From: planning.comments@york.gov.uk
Subject: FW: Planning Ref No: 21/00003/FUL

Location: Proposal :St Georges Hotel 6 St Georges Place York YO24 1DR Erection of 8no. hexagonal glasshouses to provide additional dining facility, replacement of existing shed and associated landscaping (part planning.scanning@york.gov.uk FW: 21/00003/FUL retrospective) Applicant: Mr Simon Cowton Consultation Expiry Date 17 February 2021 Case Officer: Tim Goodall Expected Decision Level DEL

Plan View

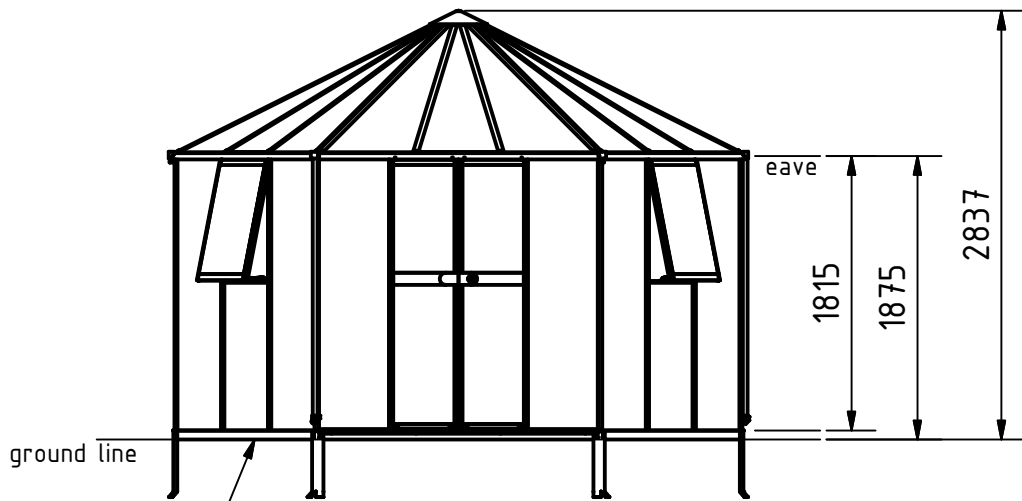
The premises were previously what would be described as small B&B in a residential area, with the owners living on the premises. What is proposed is an outdoor pizza restaurant with up to 48 covers. Very different!! This is a conservation area and the proposed pods(already in situ) are neither discreet, nor unobtrusive. In fact an eyesore!!

The provision of 3 pods placed close to the Hotel giving additional dining options and easier access to the hotel would be seen as more acceptable during COVID.
